Our ref: Oakdale West Estate-Mod-10 (SSD-7348-Mod-10)

Subject: Request for Additional Information

I refer to Response to Submissions for the Oakdale West Estate-Mod-10 (SSD-7348-Mod-10). After careful consideration, the department is requesting that you provide additional information.

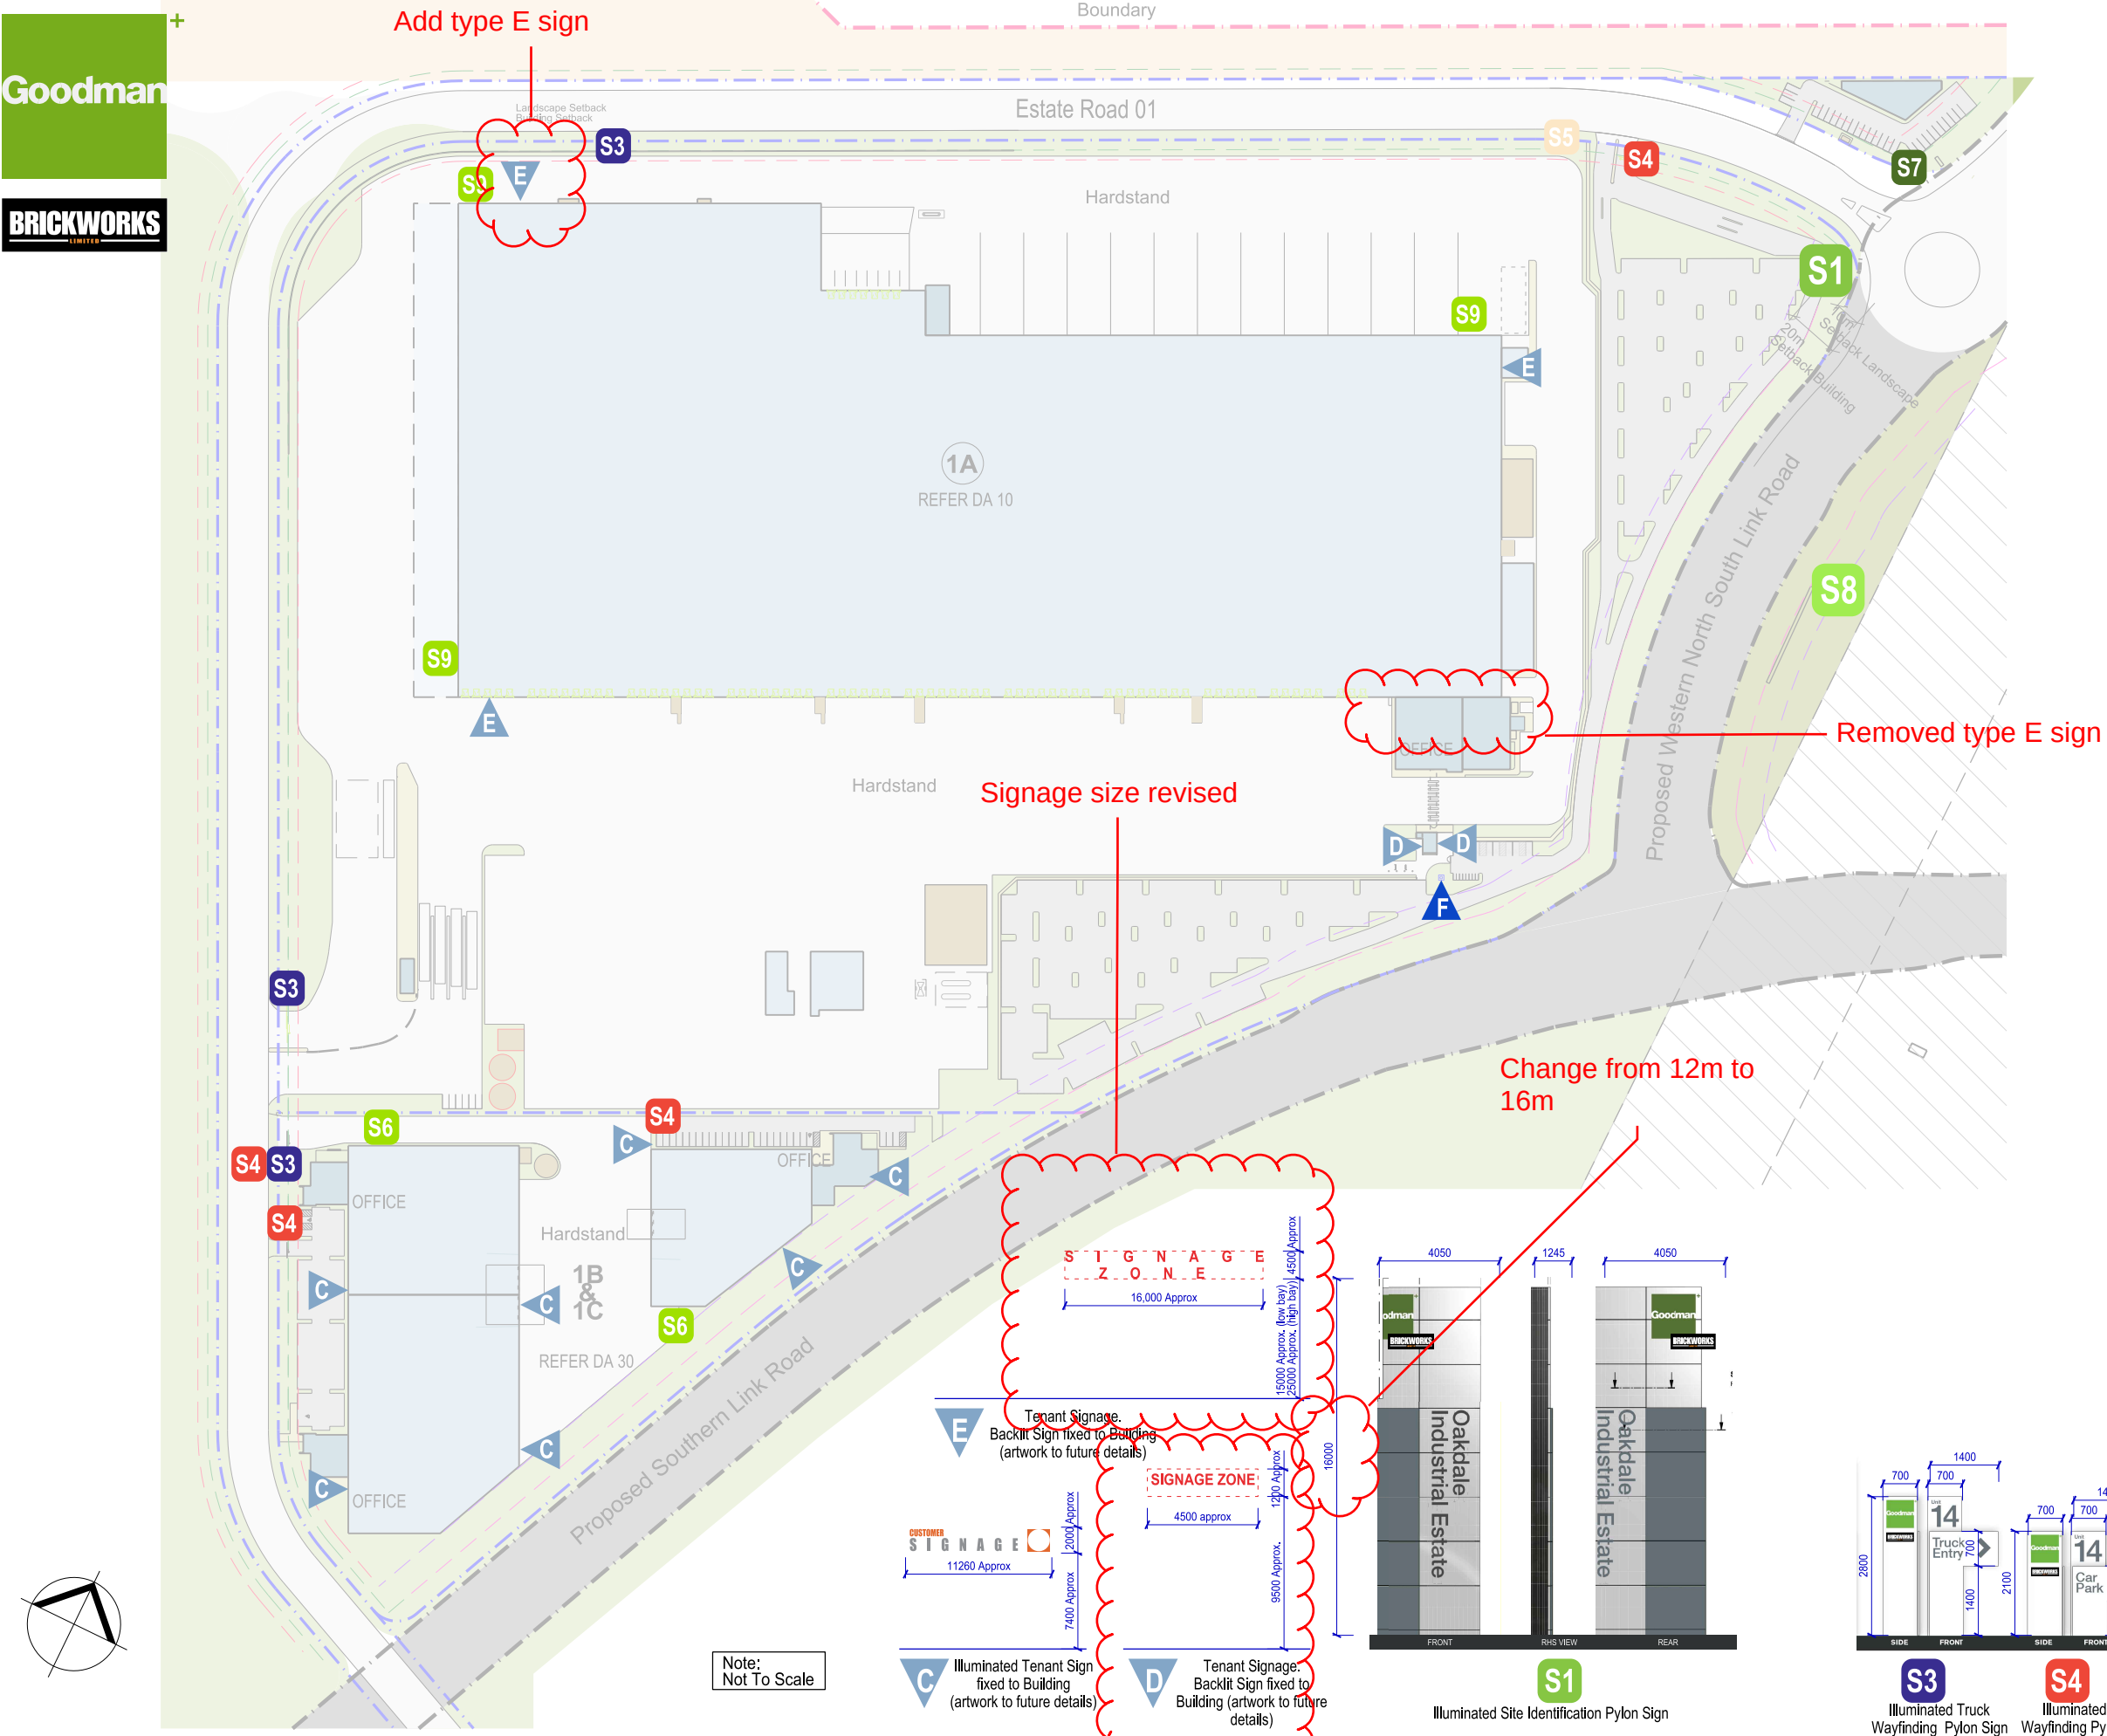
- Please address Penrith City Council's attached comments, including further justification that the 16 m pylon sign complies with Chapter 3, Schedule 5 of State Environmental Planning Policy (Industry and Employment) 2021.
